Fwd: 167 Fore Street - Permit # 201602816

the design revisions represented in the building permit application for 167 Fore Street addition do not comply with the Site Plan approved drawings.

1 | GROUND FLOOR PLAN
1/8" = 1'-0"

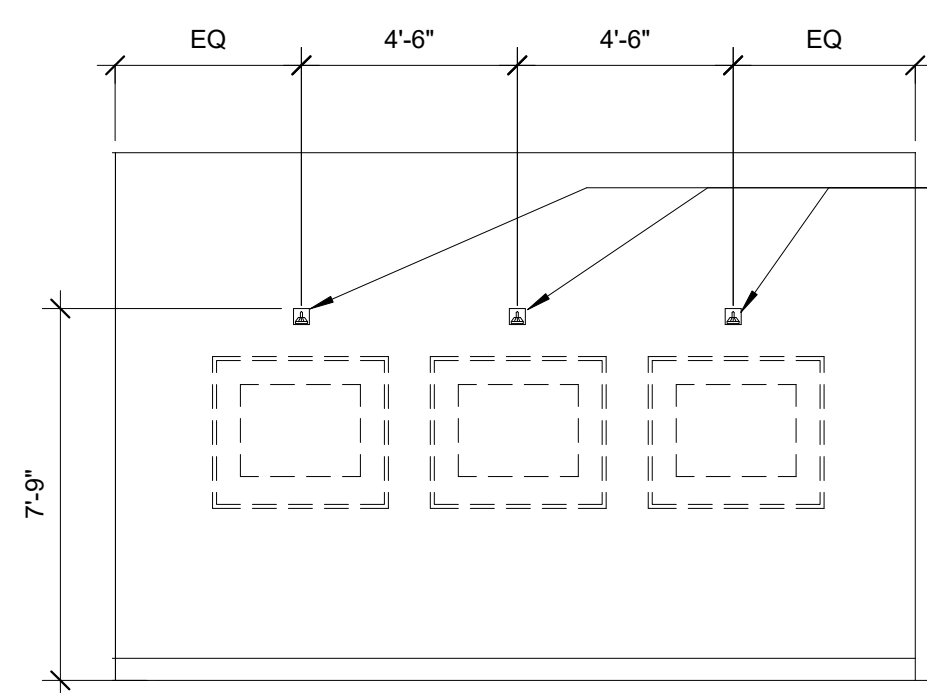
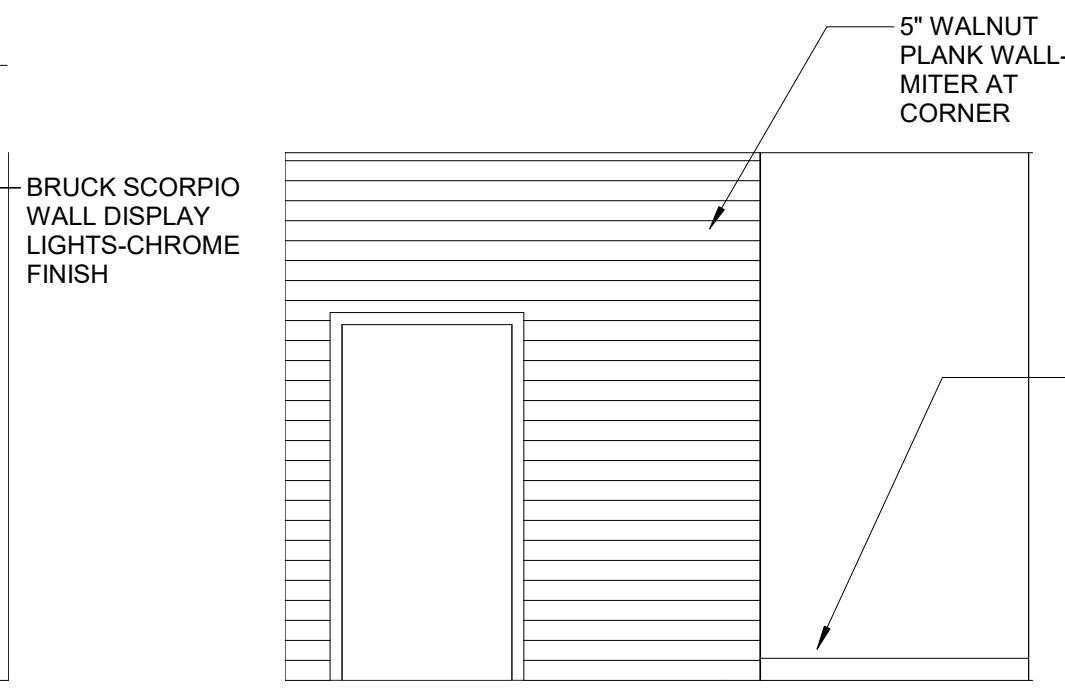
- Please provide more explanation of the changes to the ground floor retail, especially the relationship of the glazing to the brick pier. The design that was approved under Site Plan review specifically included the brick pier detail and approval was contingent on providing a strong building base where the horizontal element ties into the vertical brick supports and provides depth and a reveal. More information needed

- Ground floor commercial space is required to be transparent glass, please provide additional information for the storefront system selected at the ground floor regarding the tint and VT. More information needed.

-Please see the detail attached. For structural purposes we are running the curtainwall system continuous down to the ground. This curtain wall will be held back from the existing brick piers approx. 5" to allow for depth change between the existing and new. We can create a transition element between the ground floor retail and upper floor office, where we have the connection between the existing brick pier and new curtainwall system. Similar to the detail that was originally submitted, we plan create a horizontal element that can be supported by the curtainwall system, that would tie into the brick system. Through this metal box panel we can create reveals to break up the system and depth that would enhance separation/relationship between the ground floor and brick piers with the upper floors and curtainwall.

-Please see the glazing cut sheet attached. This is the glazing we are planning to use.
